Application for Planning Permission for Works or Extension to a Dwelling

Development: Garage conversion, porch infill and external alterations.
Location: 32 Normans Drive Felpham PO22 8LW

Proposed Elevations

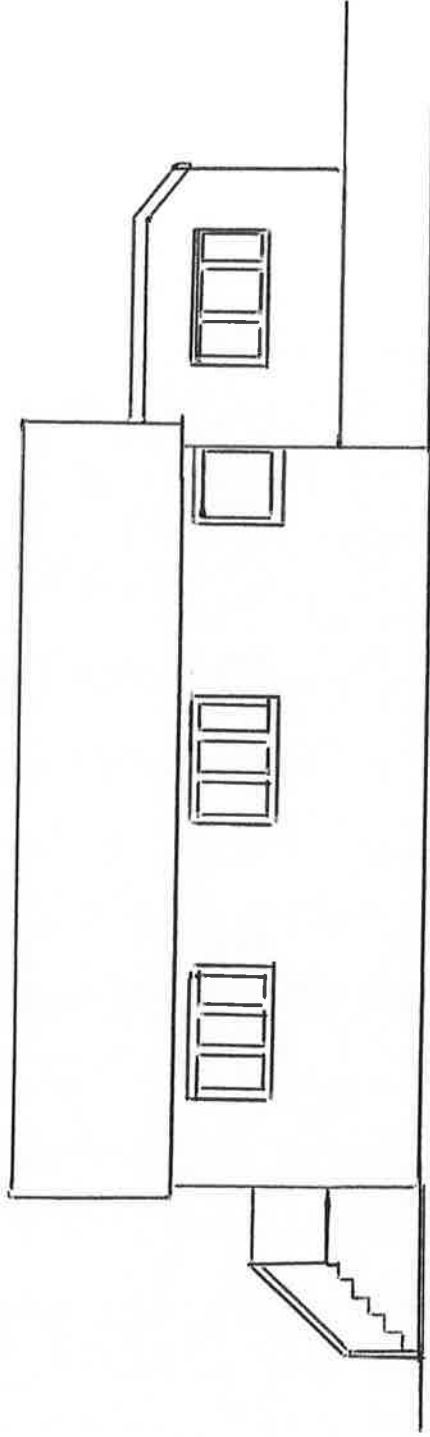
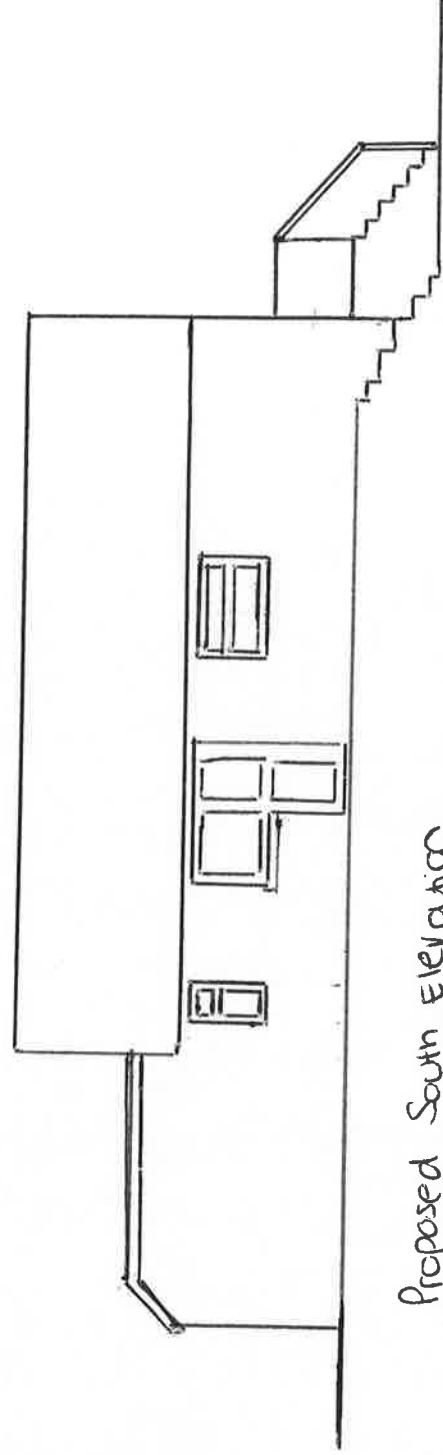
The Elevations need to show any steps/foundations/etc in context to the dwelling.
